29 FLORIDA STREET  
SYLVANIA (SSD-83258708)

RESPONSE TO SUBMISSIONS

REVISION 04

26.03.26

TYPICAL APARTMENTS -
MARKET BUILDING 1A

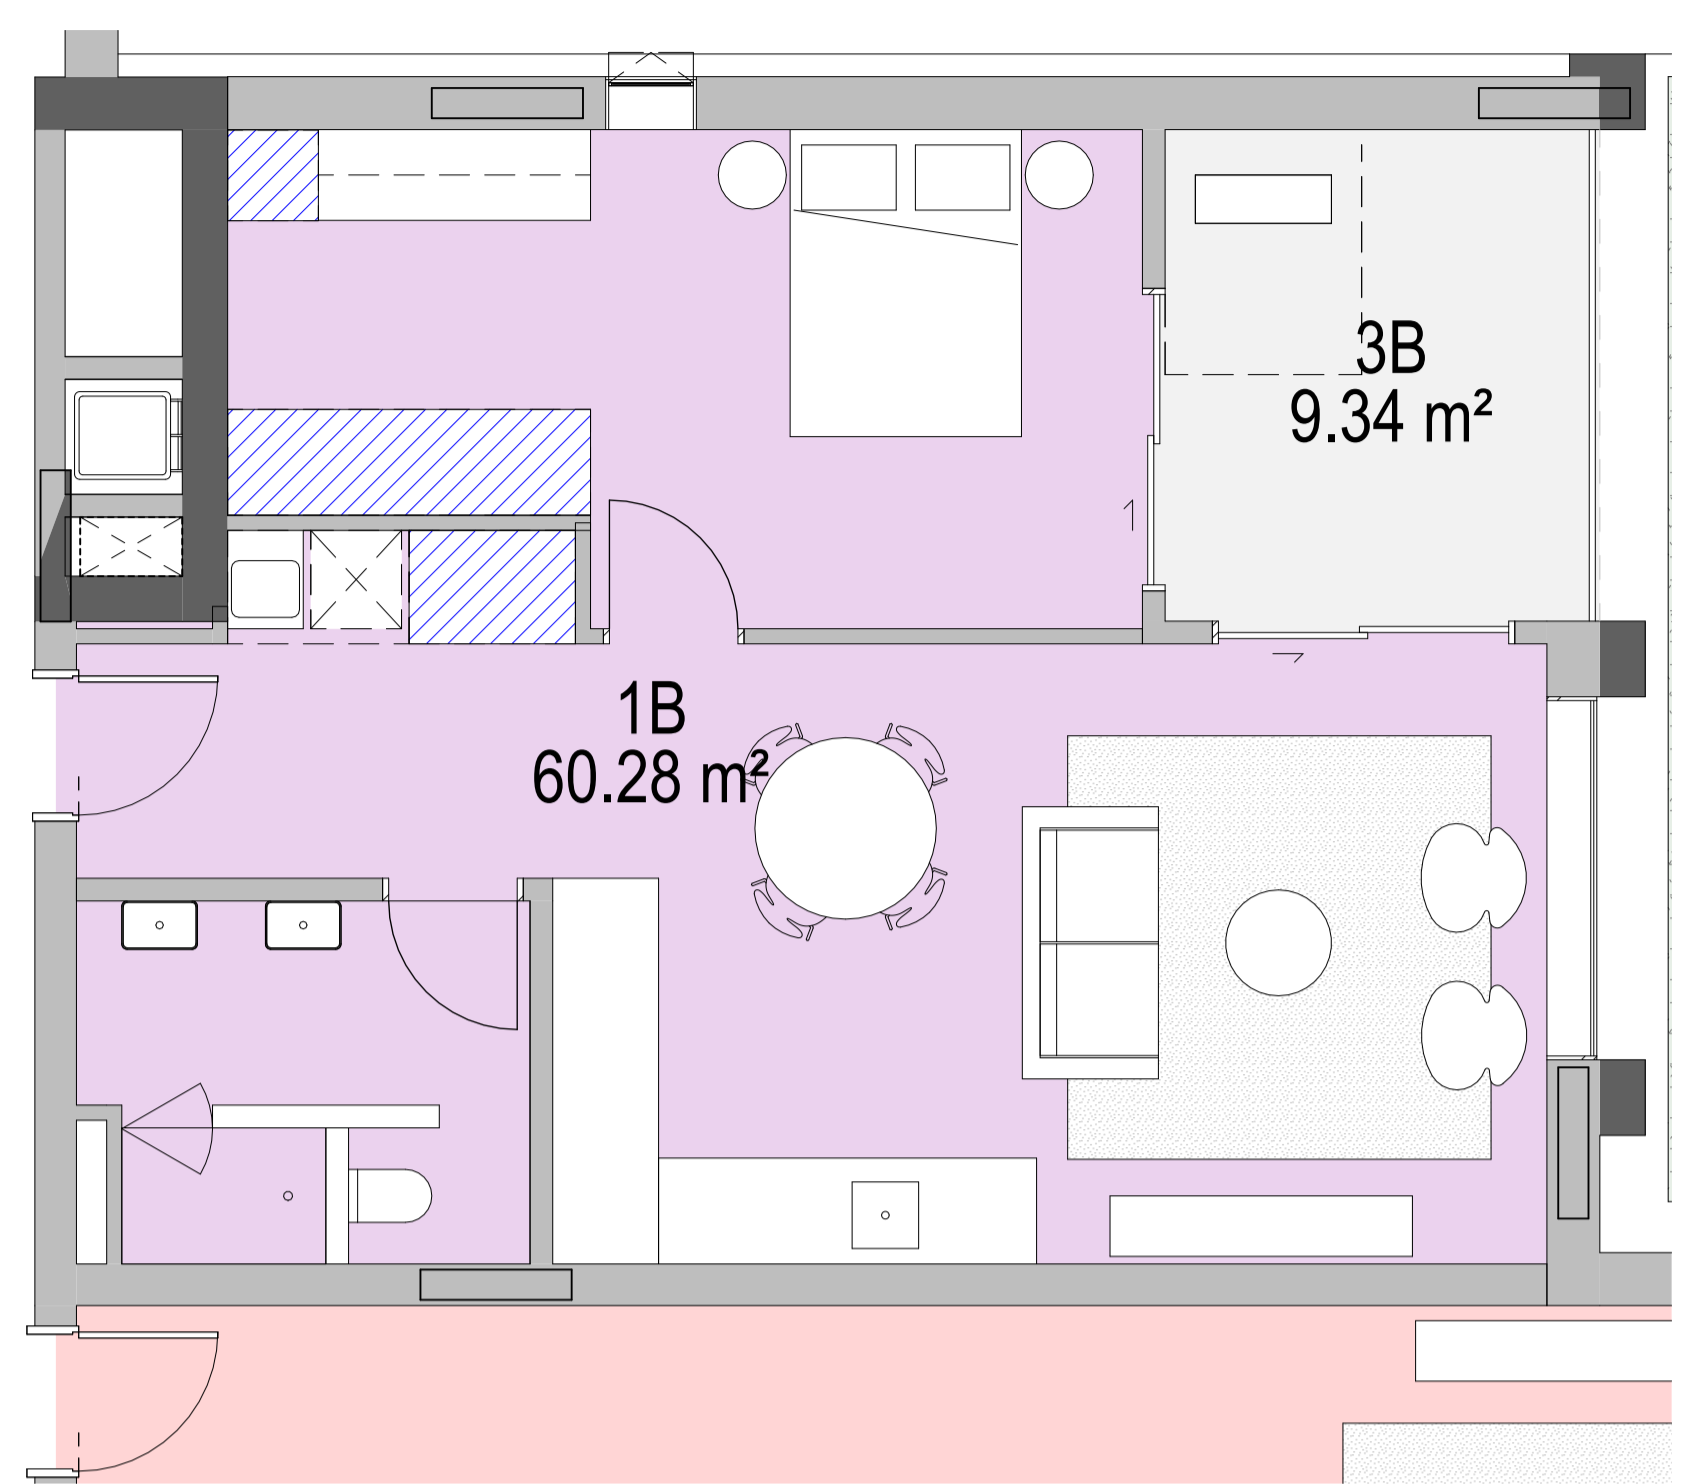
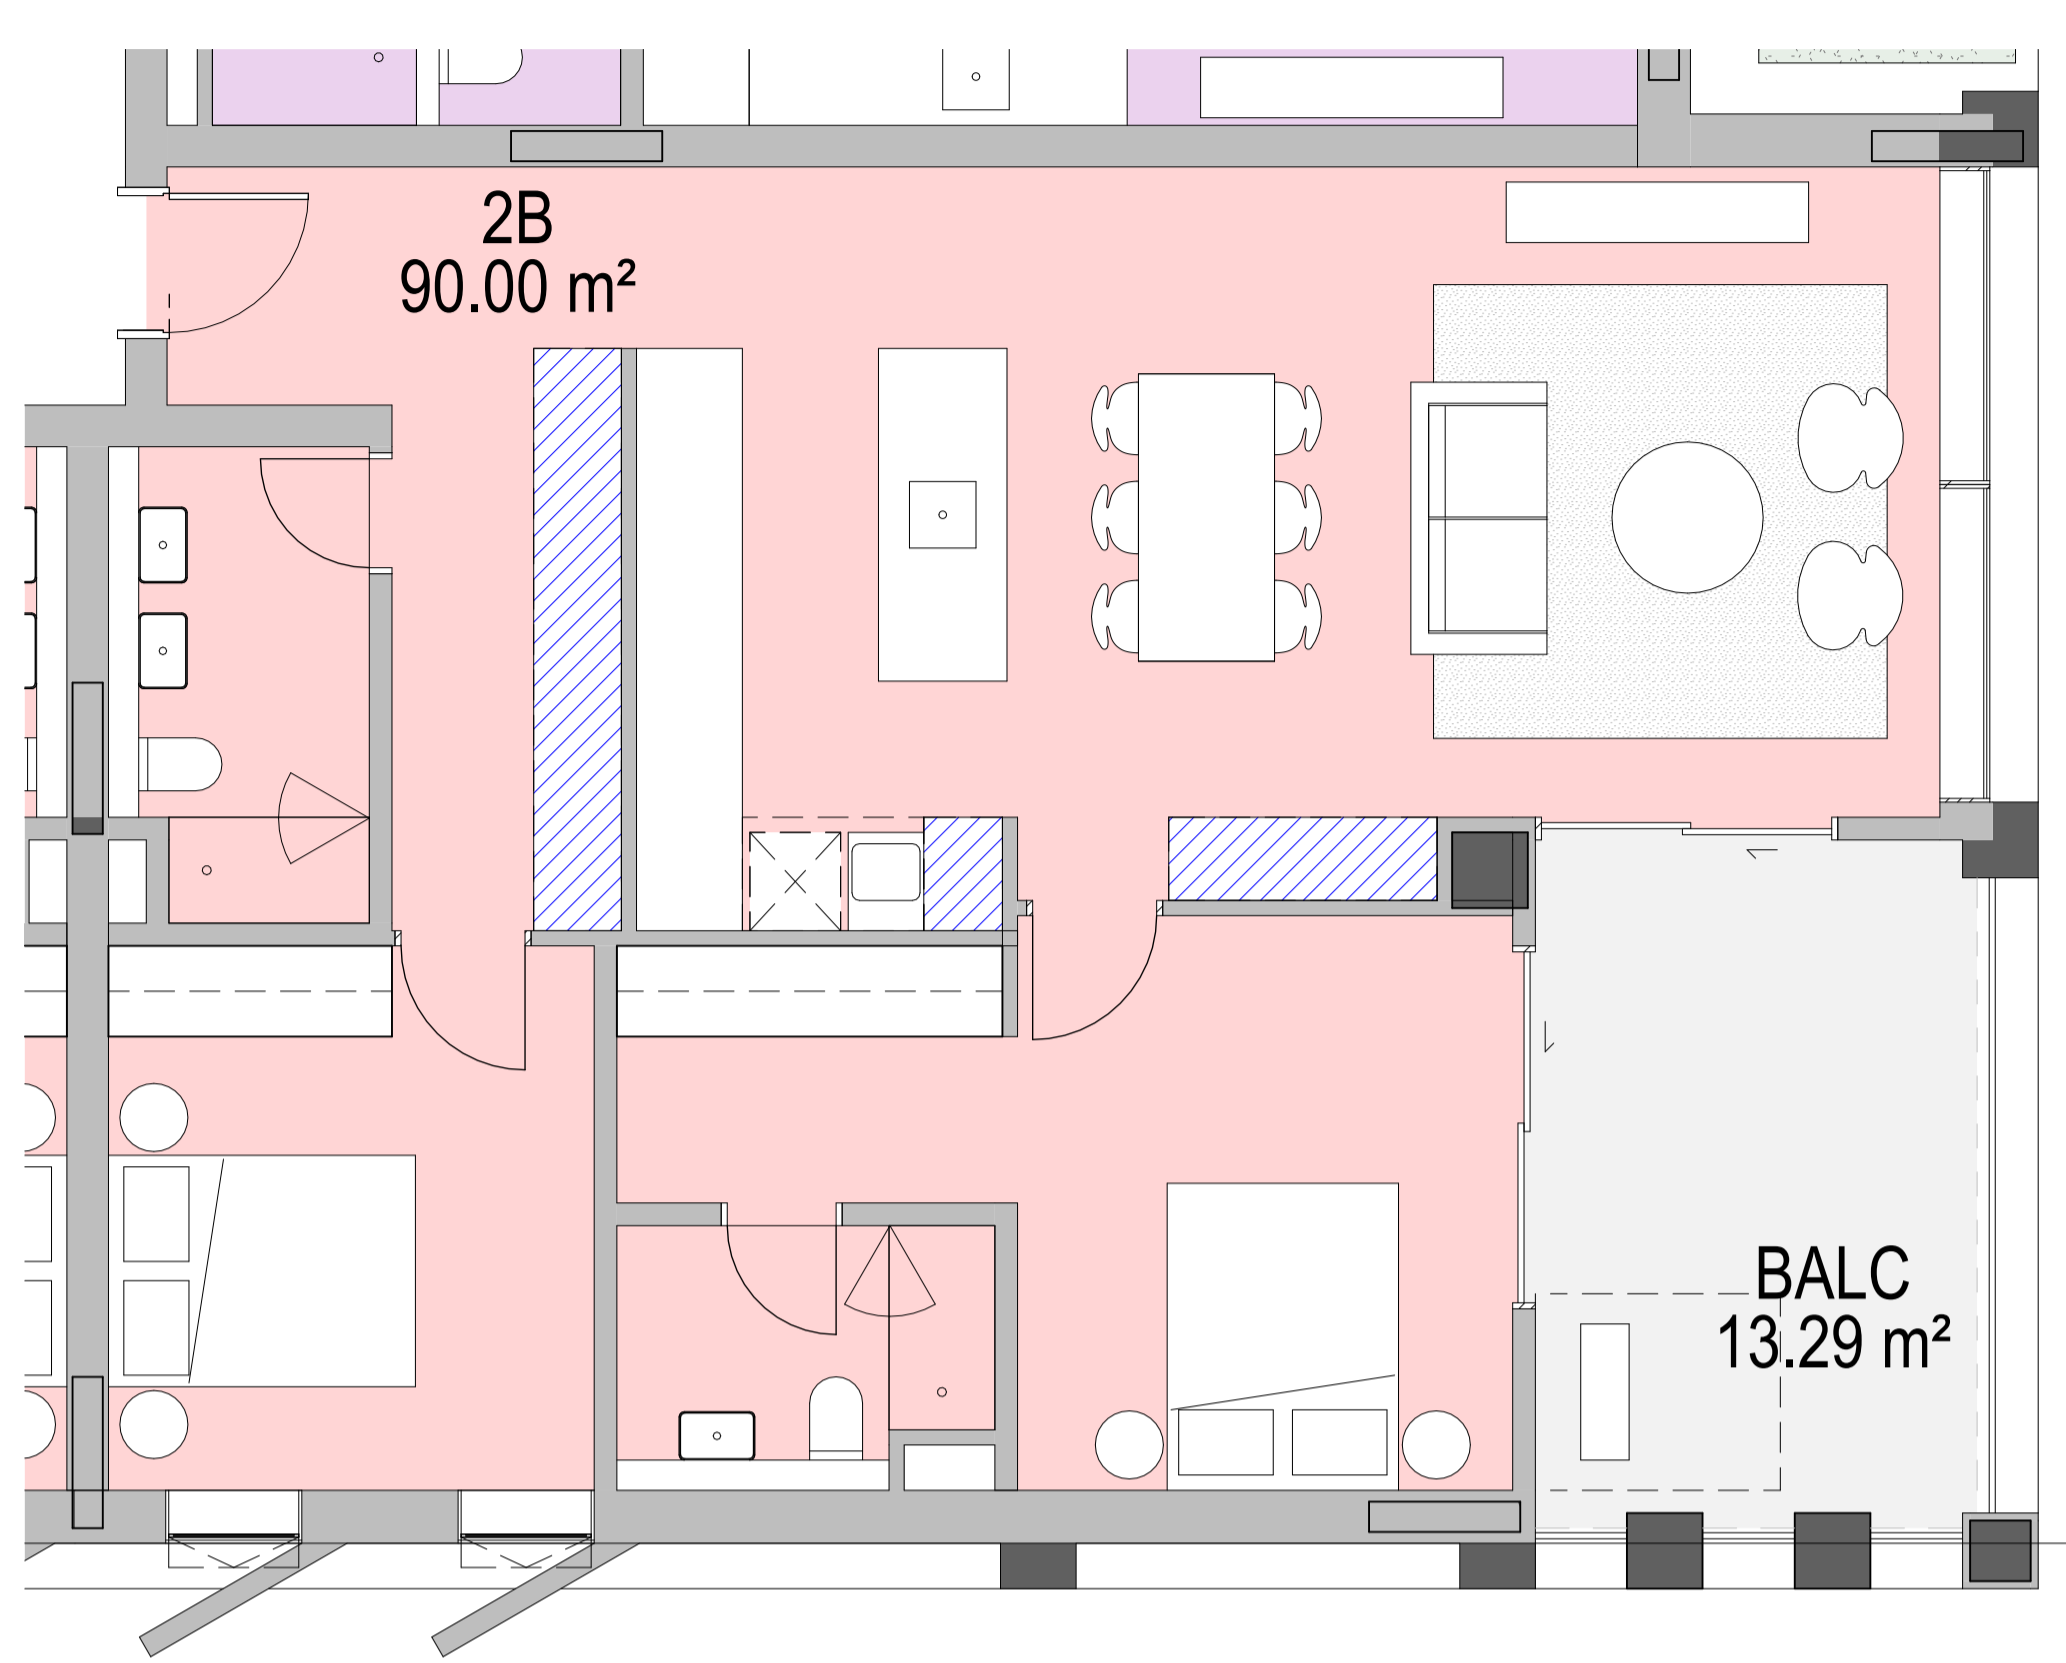
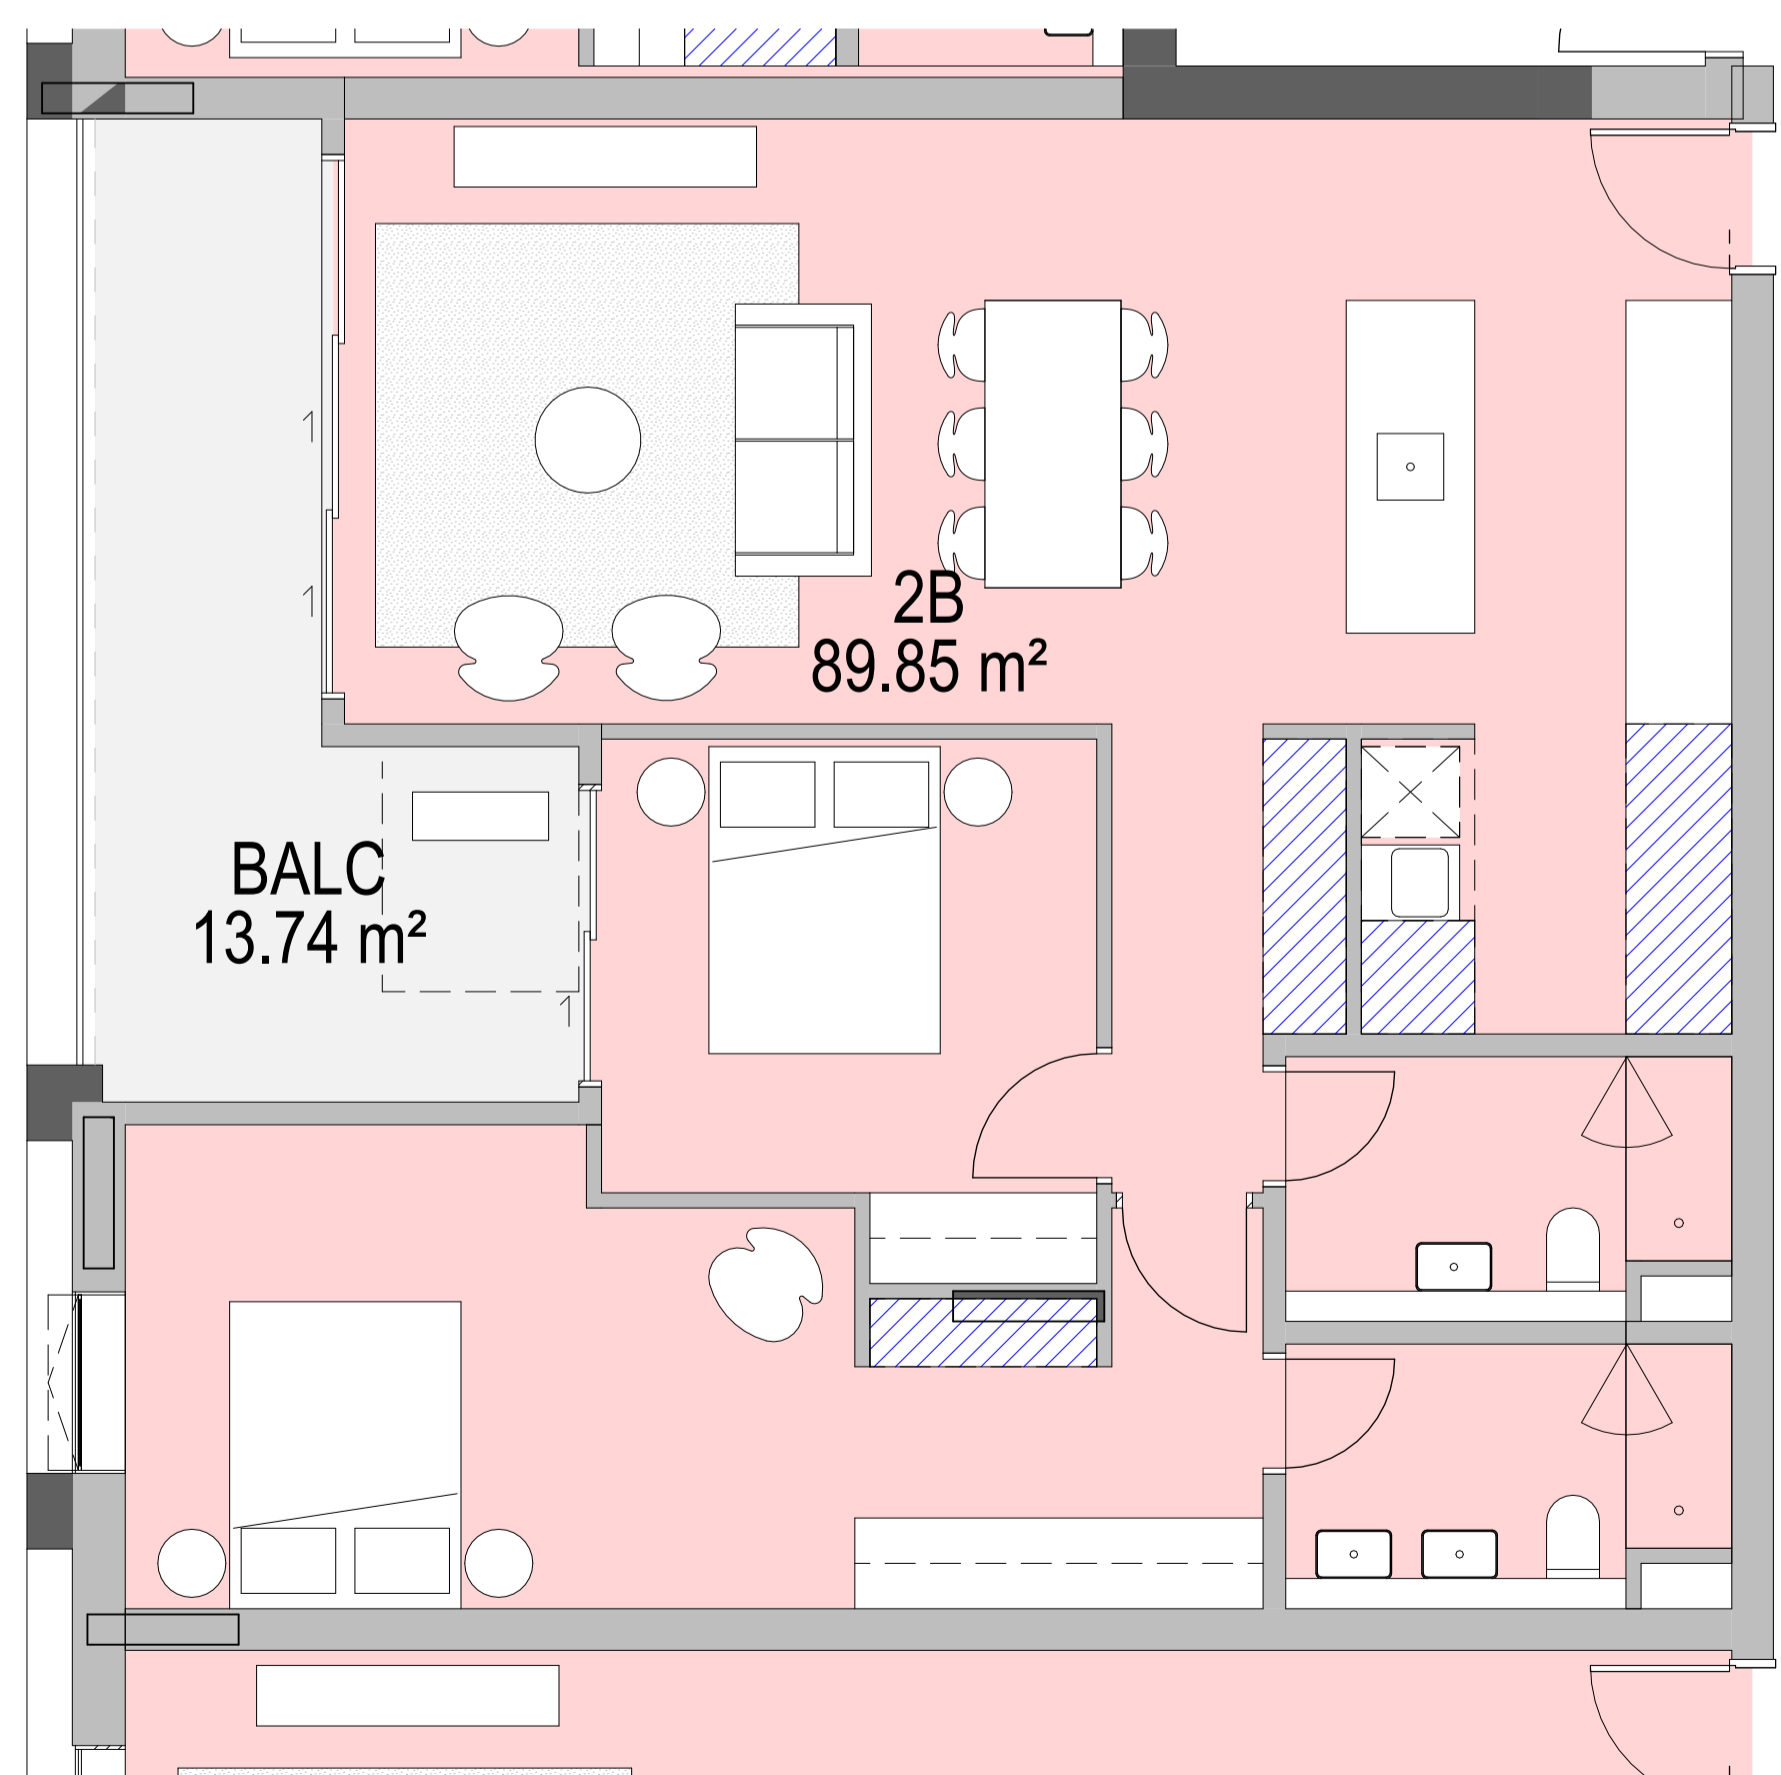
NO.	ISSUE RAISED	RESPONSE
BUILT FORM & URBAN DESIGN		
5.4	Provide annotated dimensions on plans that demonstrate all apartment sizes and layouts, and private open space areas are functional and provide a high standard of amenity having regard to the relevant design criteria of Part 4 of the ADG, specifically, Part 4D and Part 4E.	Annotated dimensions have been shown on plans for typical apartments below.
